Planning Ref. M/42/17/HH

We are writing to object to the proposed development at 14b Sea Way, Middleton-on-Sea.

GROUND FLOOR

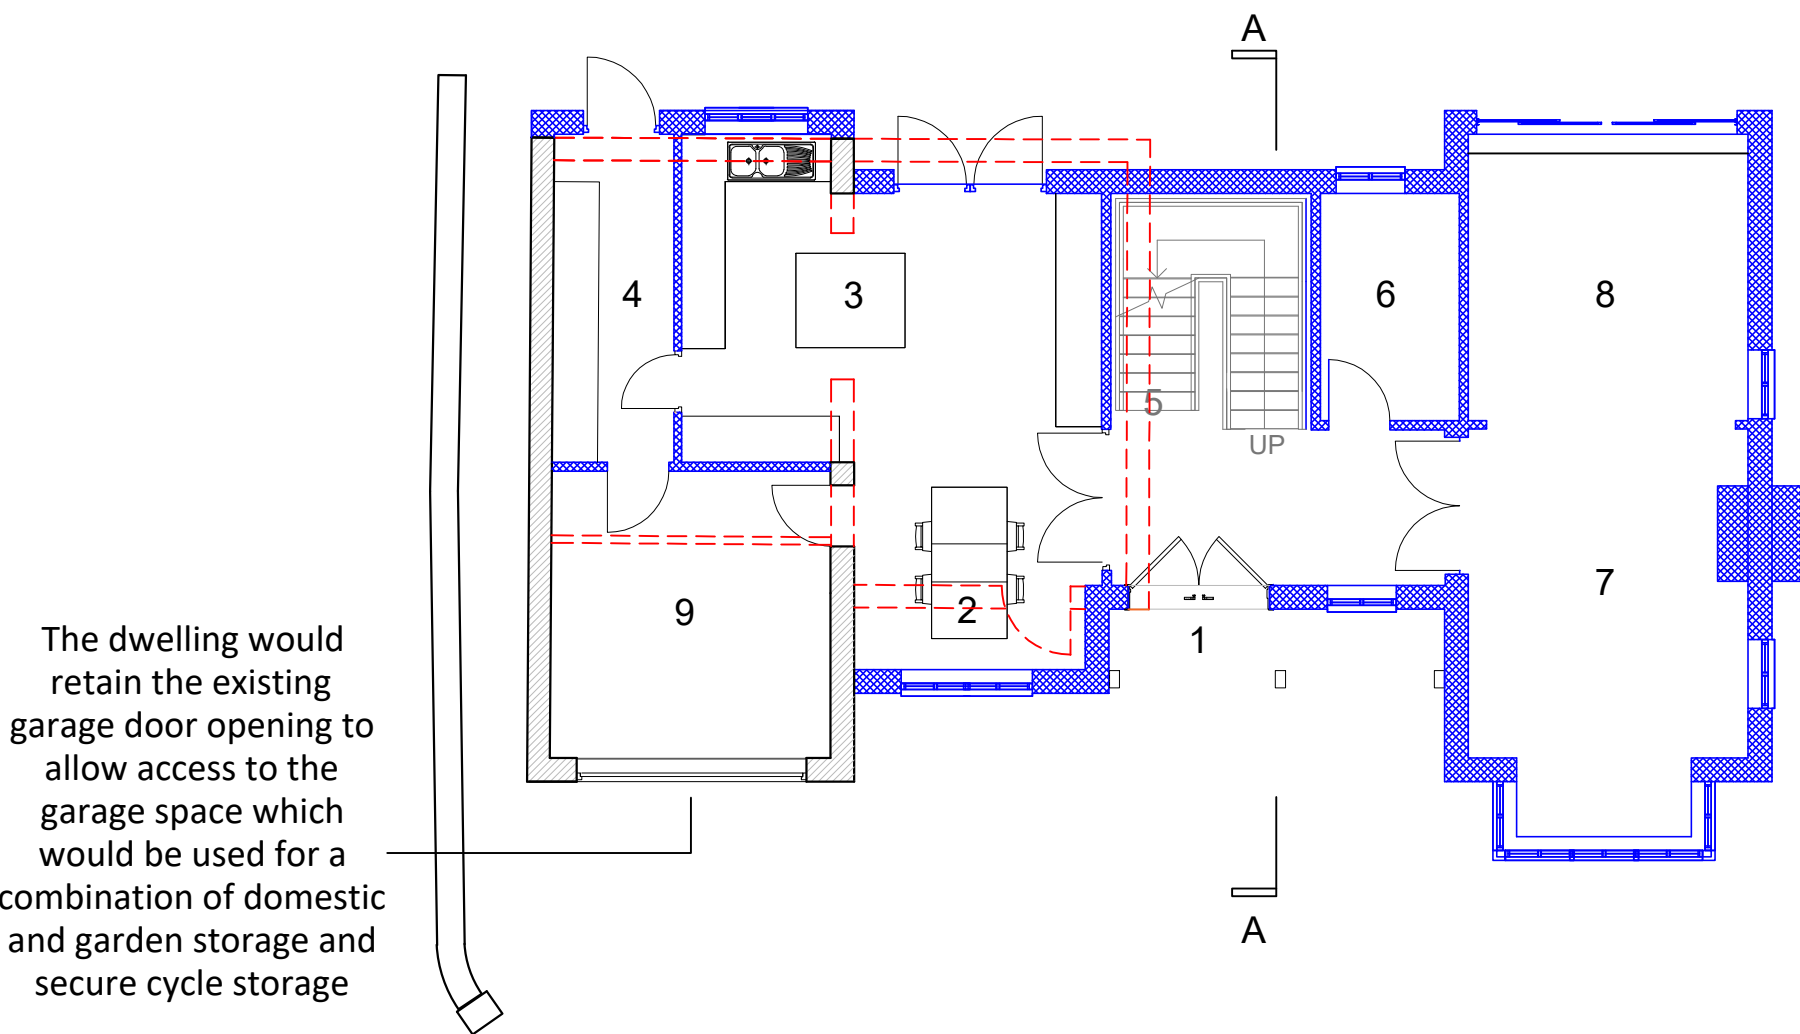
The proposal makes no provision for the garaging of cars although the design retains the existing garage door, designating a "domestic/garden/cycle storage" area behind.

Is a newly constructed 4 bedroom property without a garage a realistic or feasible long term proposition? Or is a longer game being played and will subsequent incremental planning permission be sought for a "small extension" to provide garaging commensurate with a property of that scale?

Proposed South West Elevation
Scale - 1:100

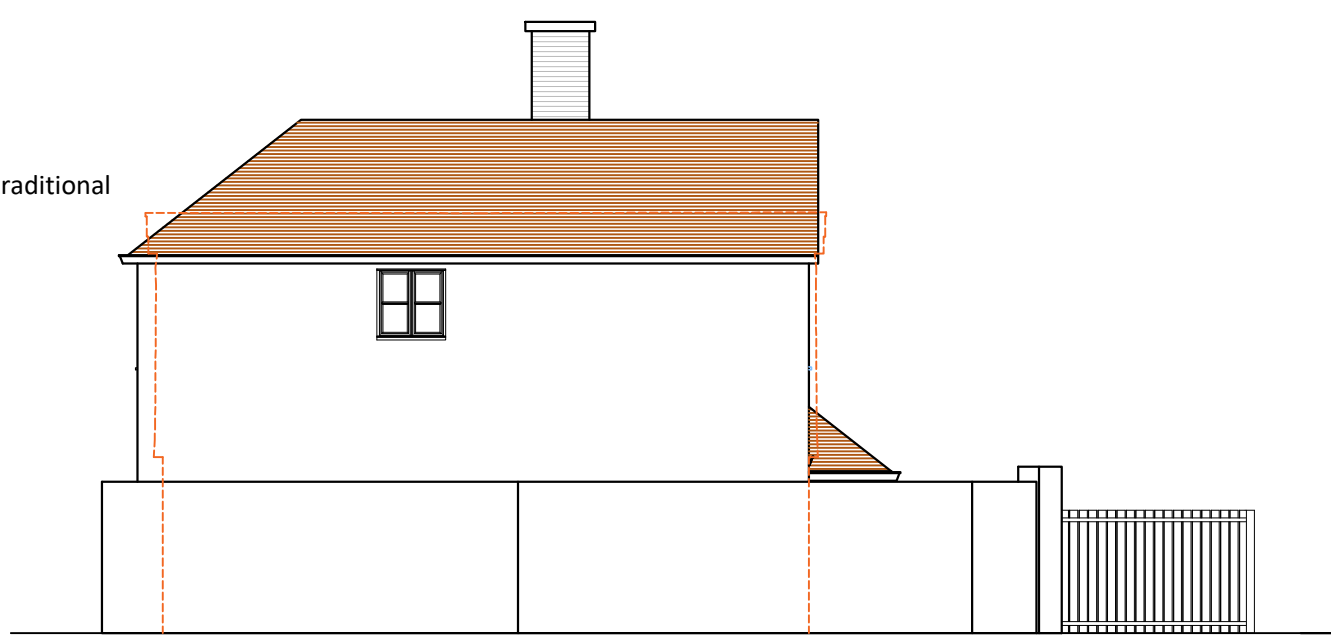
The proposed house would be an invasion of our privacy. The design reveals 7 first floor windows (4 at the SW front and 3 to the SE side) overlooking our house and garden.
